ACCESSIBILITY REPORT

SITE 13 SYDNEY OLYMPIC PARK

ACCESSIBILITY REVIEW

14th February 2008

Sydney Olympic Park Site 13
L01-L03
Typical Floor Plan

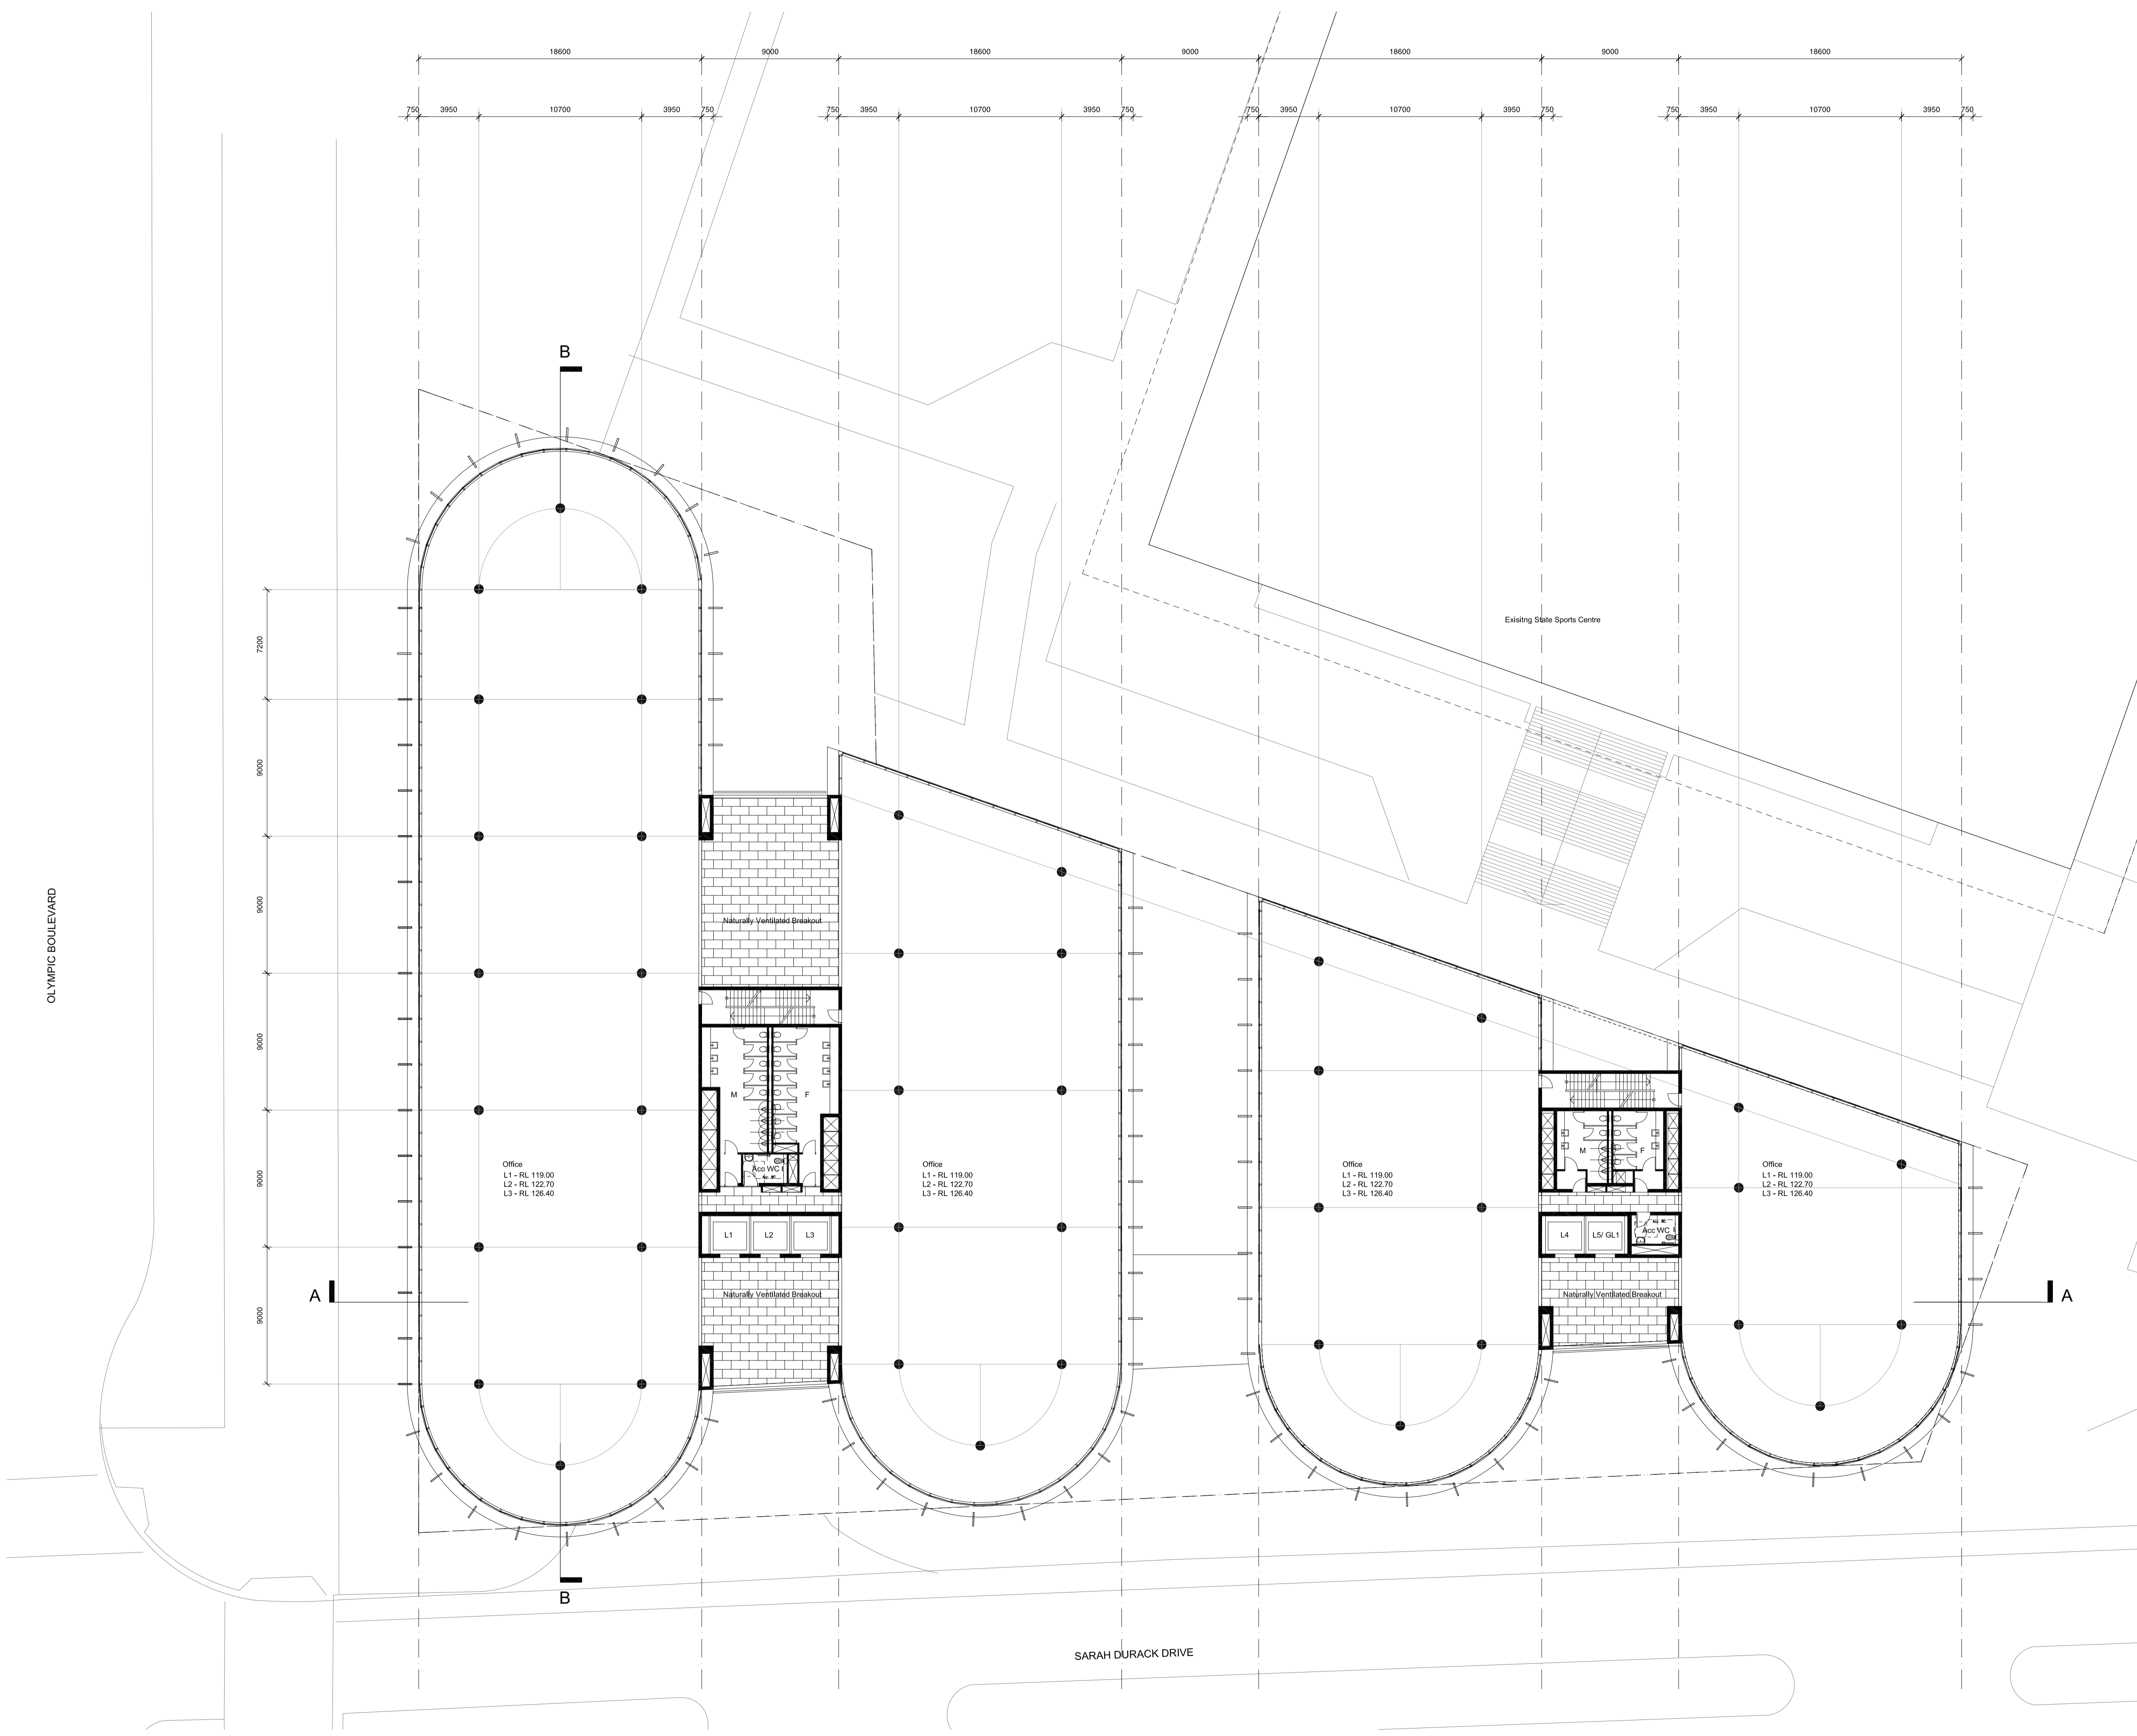
There is a corridor between the lifts and the accessible toilet on the following levels:

- between the offices and in front of lifts L1, L2, & L3 on the corner of Sarah Durack Drive & Olympic Boulevard, levels 1-4.
- adjacent to the office on the western side of the building & in front of lifts no-L4 & L5, on floors Level 1-3.

The above mentioned corridors have a clear width of 1300mm, which are compliant with the BCA, AS1428.1 & the Sydney Olympic Park Access Guidelines (June 2002)

There is a unisex accessible toilet located adjacent to the lifts L1, L2 & L3 on the ground floor & levels 1-4. There is a unisex accessible toilet located adjacent to the lifts L4 & L5 on the ground floor & levels 1-3.

All accessible toilets on all levels have internal dimensions of 2900mm x 1900mm, which is compliant with AS1428.2 & the Sydney Olympic Park Access Guidelines (June 2002).

The approach corridors leading to the accessible toilets on each level have clear widths of 1200mm, which are compliant AS1428.1-figure 12.
